RE: SP-25-00001 Graf Short Plat – City of Ellensburg Comments (File # EX25-001)

RE: Proposed Graf 2-Lot Short Plat

LOCATION: 2601 Hannah Rd – Parcel ID # 841133

GRAF SHORT PLAT

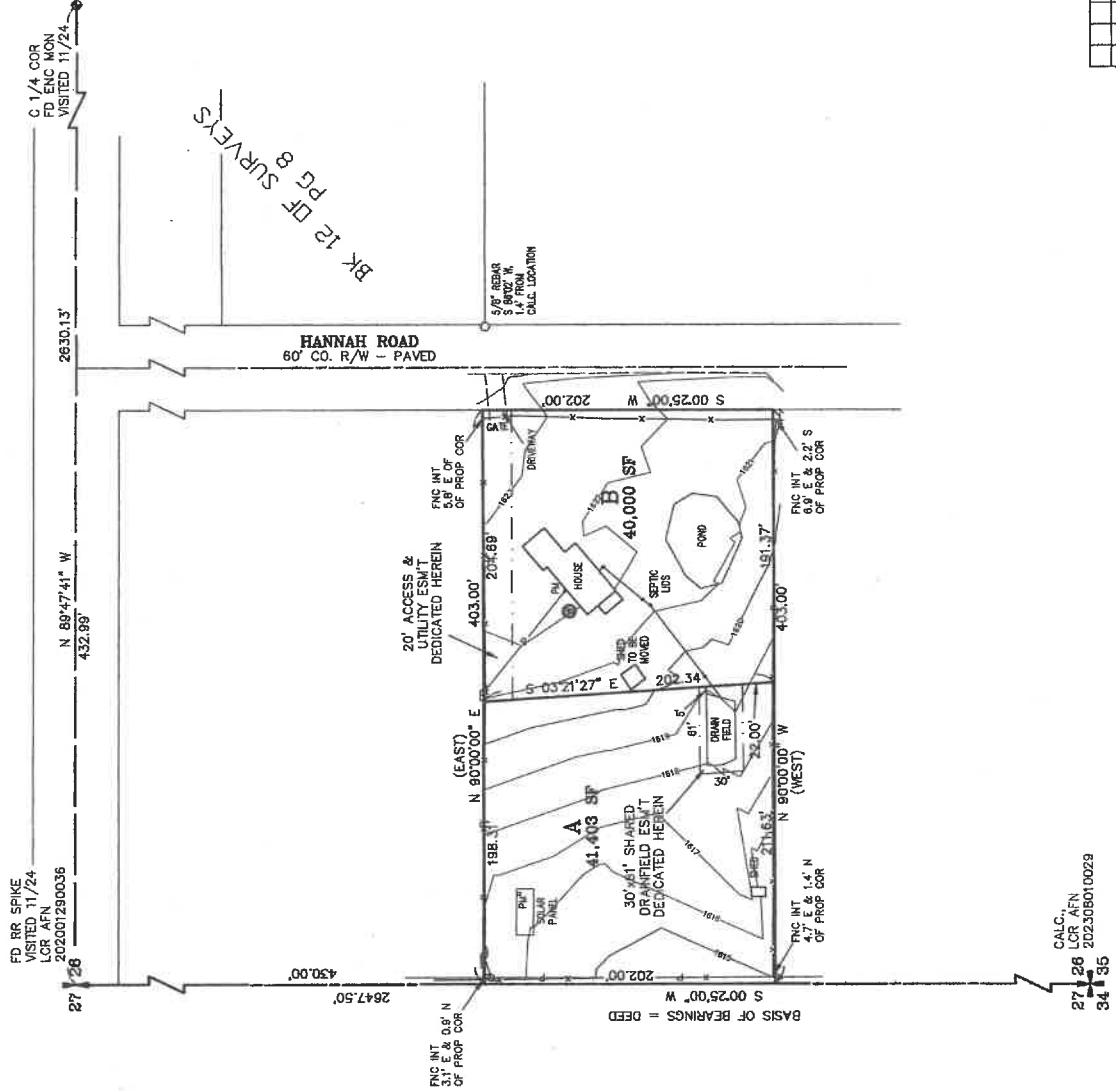
COE Light Dept. Requires a 10ft utility easement along Hannah Road. Contact the County PUD if they require a 10ft easement for their pole lines on lot "A". It may be in the applicant's interest to provide an easement for the solar panels and its equipment if they are to continue to provide power to lot "B".

Ellensburg Planning noted solar panels on proposed Lot A, presumably providing power to the residence on proposed Lot B. Applicant may wish to consider recording a private easement for these panels and its electrical service that crosses lot boundaries on the face of the plat.
